Issue Specific Hearing 11 (ISH11) on Flooding, Water and Coastal Processes
Theberton and Eastbridge Parish Council, Stop Sizewell C and Minsmere Levels
Stakeholders Group

Oral Contribution by Cllr. Paul Collins

TEMPORARY COASTAL DEFENCE FEATURE GENERAL ARRANGEMENT

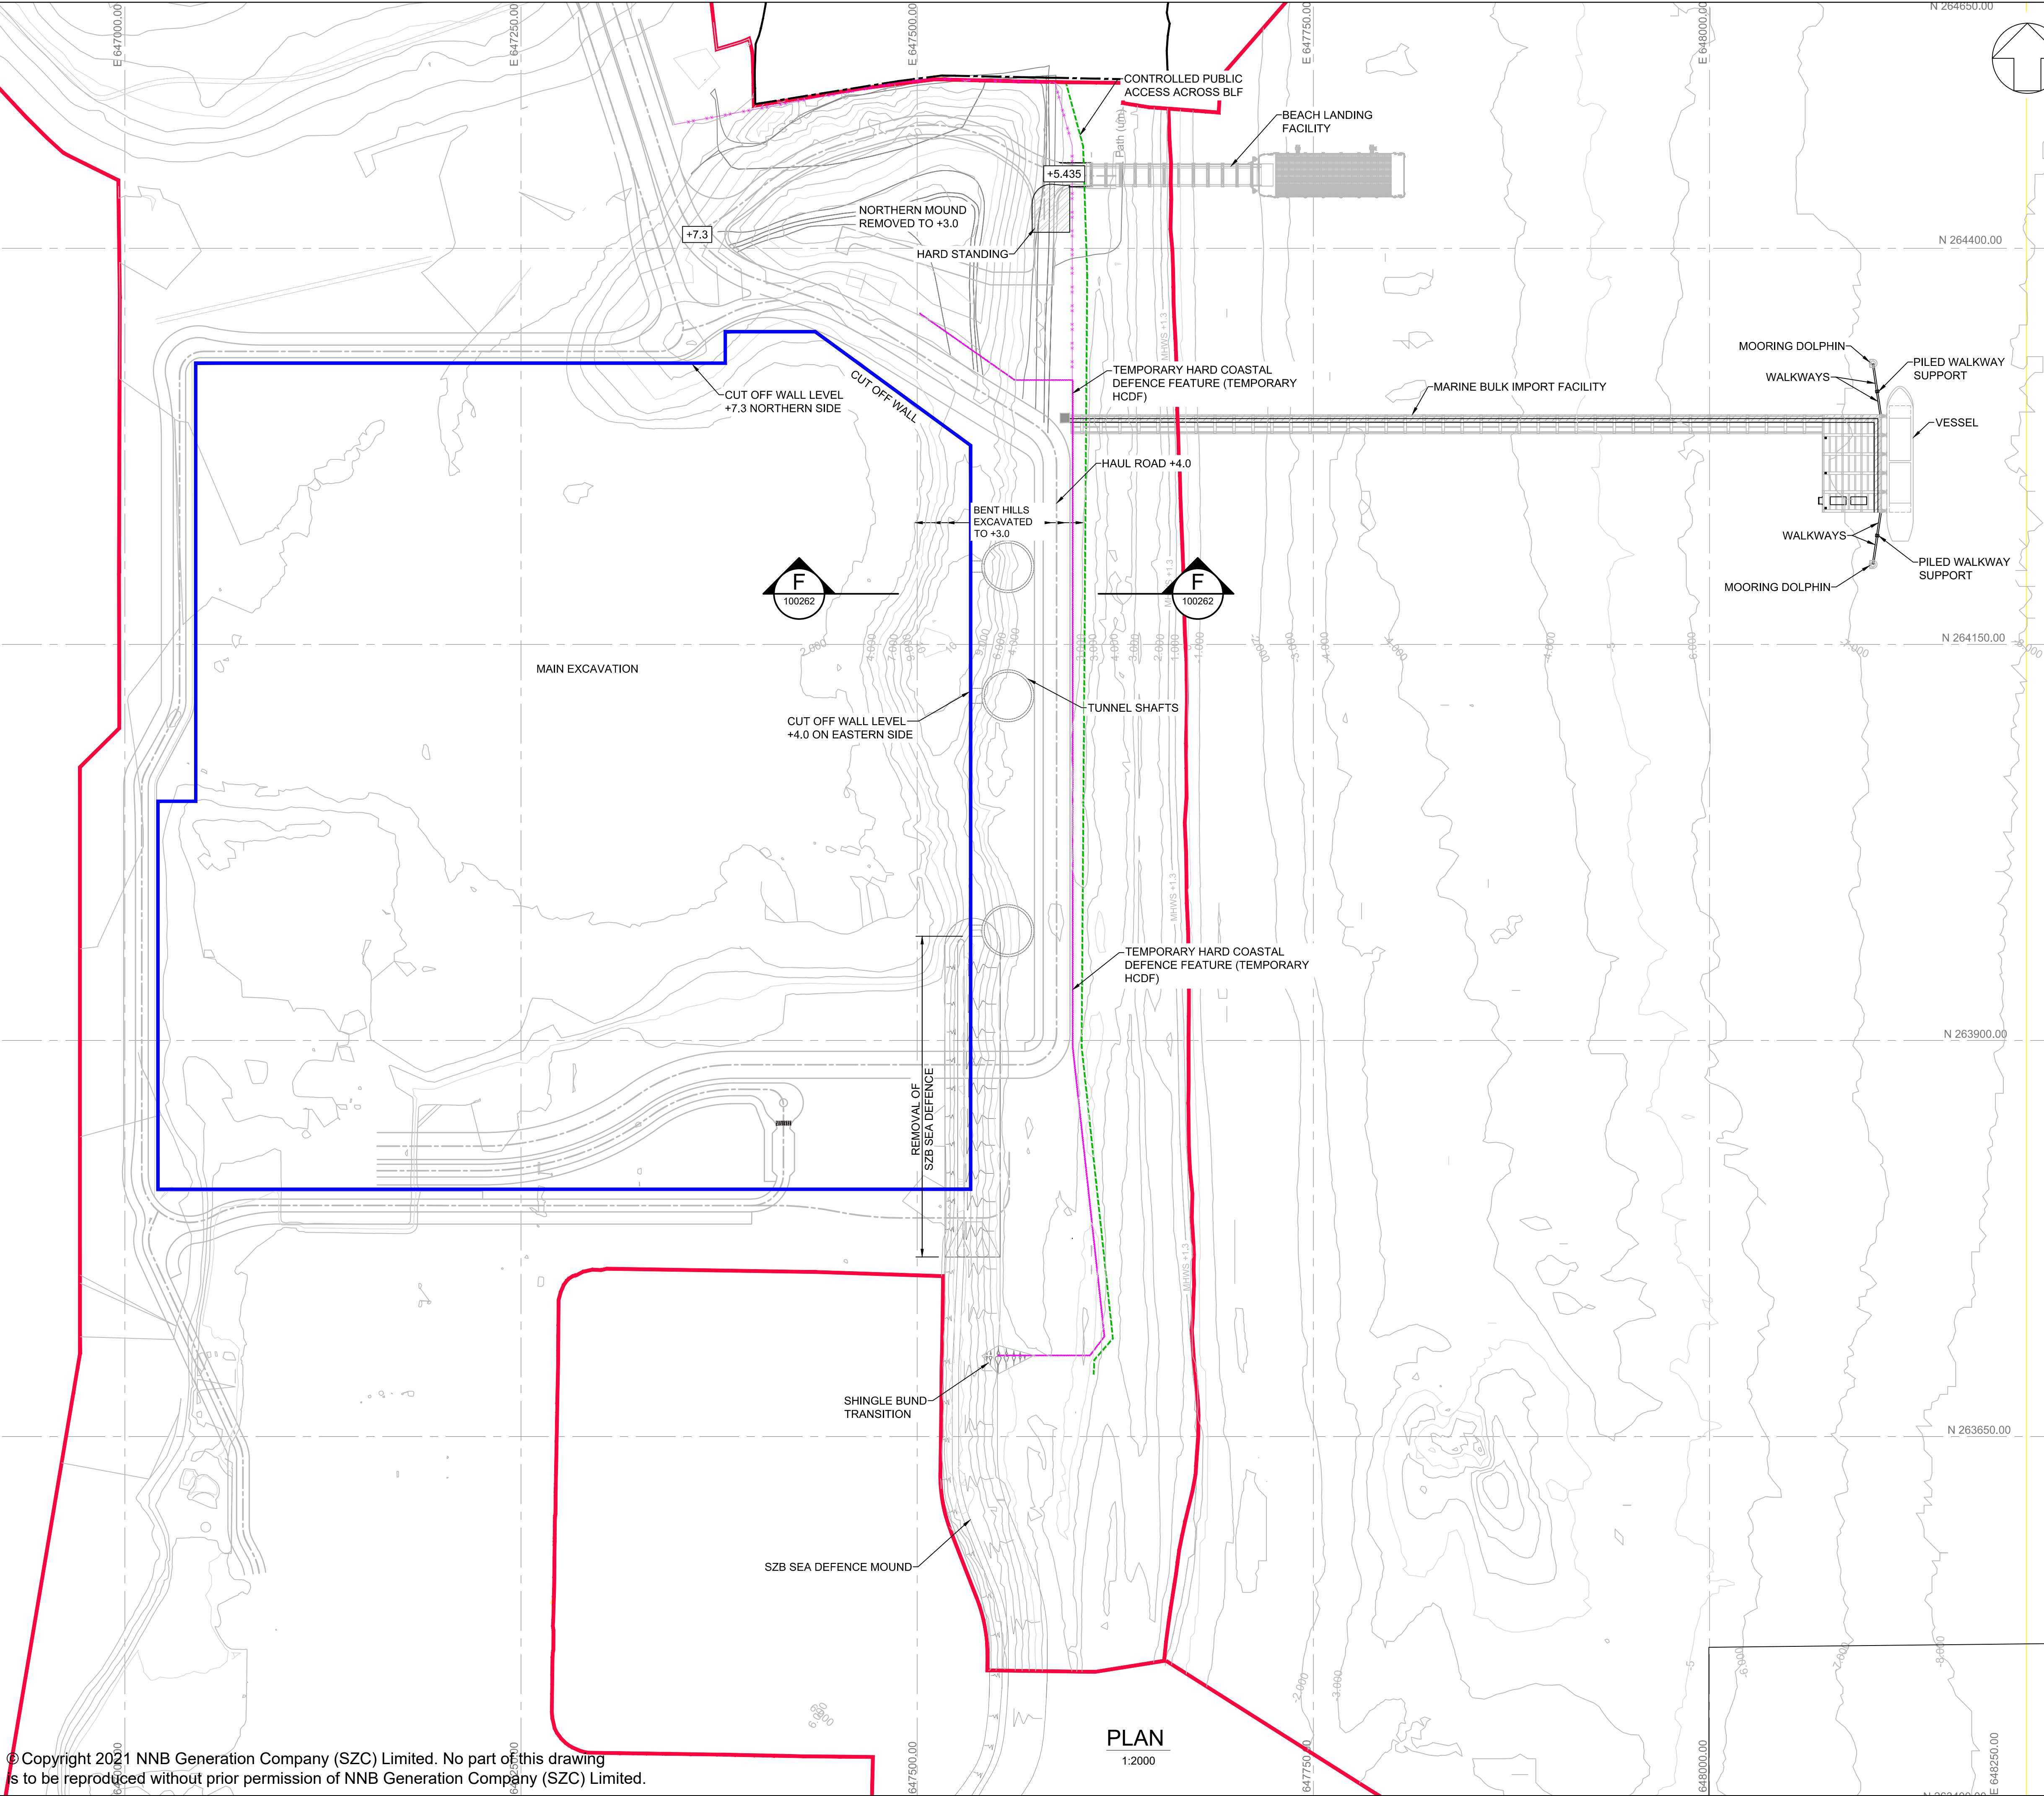
- The current plans of the HCDF overlayed onto the light grey contours of the underlying OS map in [REP5-015](#) (and shown above) do not give a clear indication of where the southern 150- 200m of the HCDF are compared to the current sacrificial dune, hydraulic salient of SZB or the natural embayment profile of Sizewell Bay.

DRAWING TITLE:
PERMANENT COASTAL DEFENCE FEATURE
TYPICAL SECTIONS (MAIN)

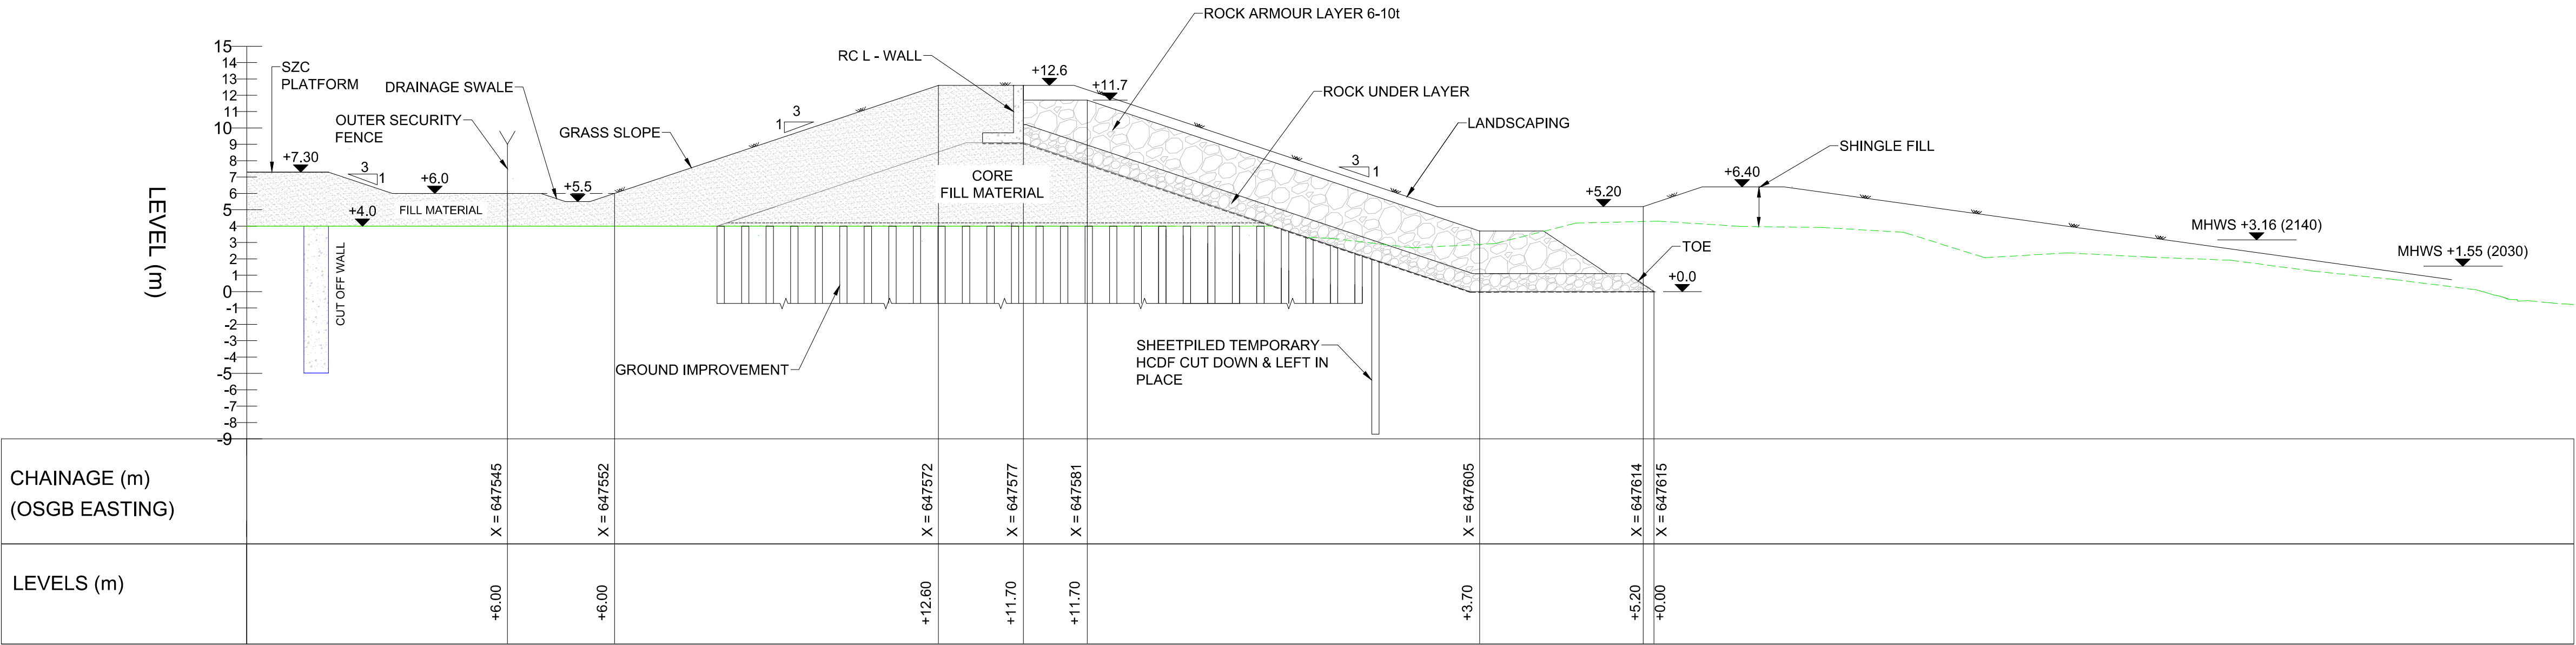
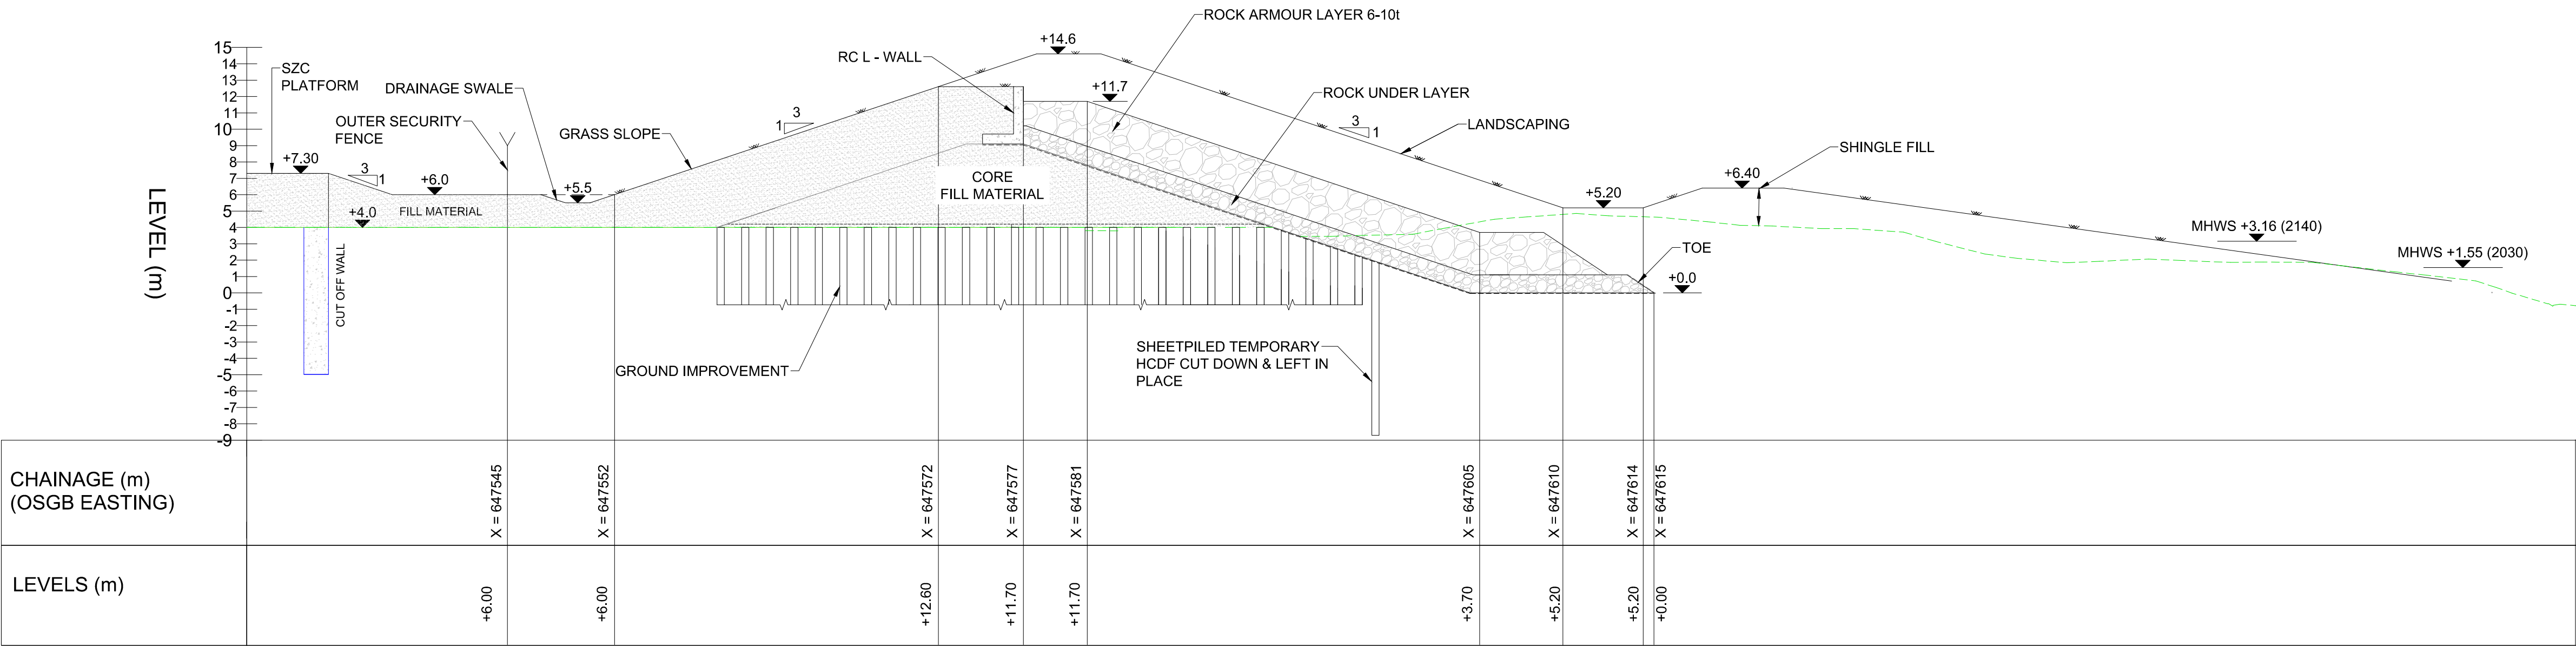
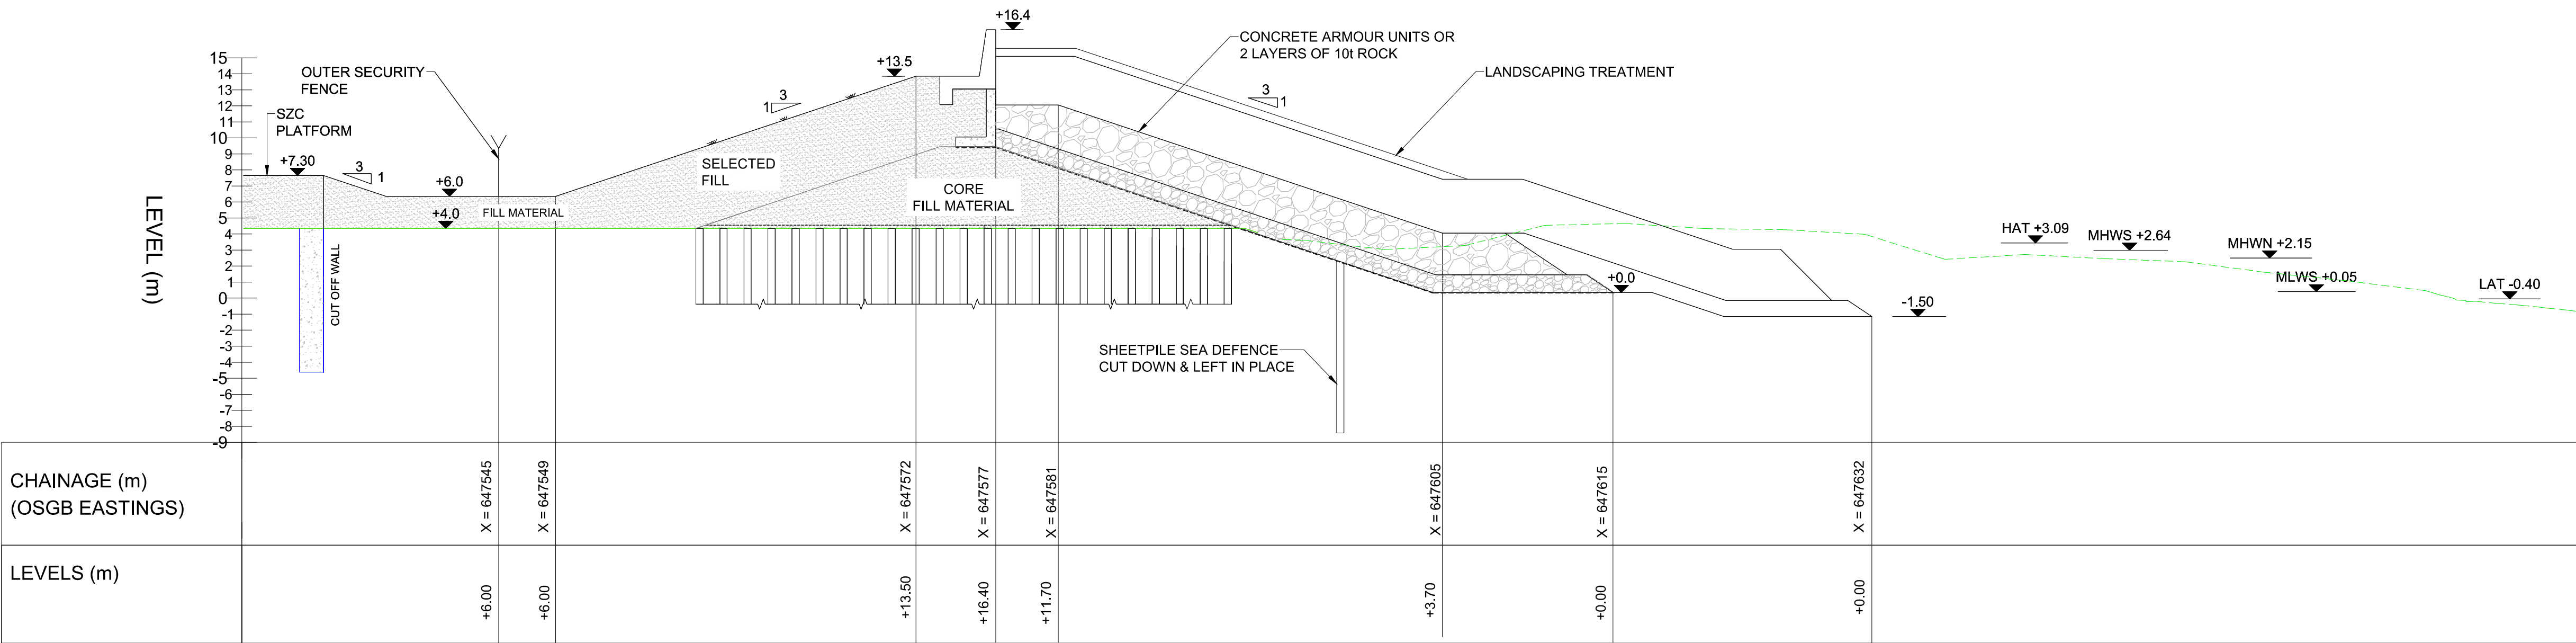
- *So, we now come to the Soft Coastal Defence. In [REP5-009](#) 5 cross sections of the HCDF are given, three profiling the new northern mound and two showing the profile of the eastward facing beach defences. In both cases the SCDF profile runs from the +6.4m AOD apex of the new sacrificial dune to the 2030 MHWS at ~+1.5m AOD. The most southerly of these two is north of the point where the HCDF toe crosses the existing sacrificial dune to the vegetated shingle that is part of the SZB hydraulic salient.*

- *No cross sections are given of the HCDF/SCDF profile south of the inflexion point or at the maximum south-easterly point close to where the HCDF terminates and the interface to the existing SZB HCDF is proposed. This is where the SZB salient is at its most extensive and can be seen in the drone pictures of Sizewell Bay above (**Figures 2 & 3**).*
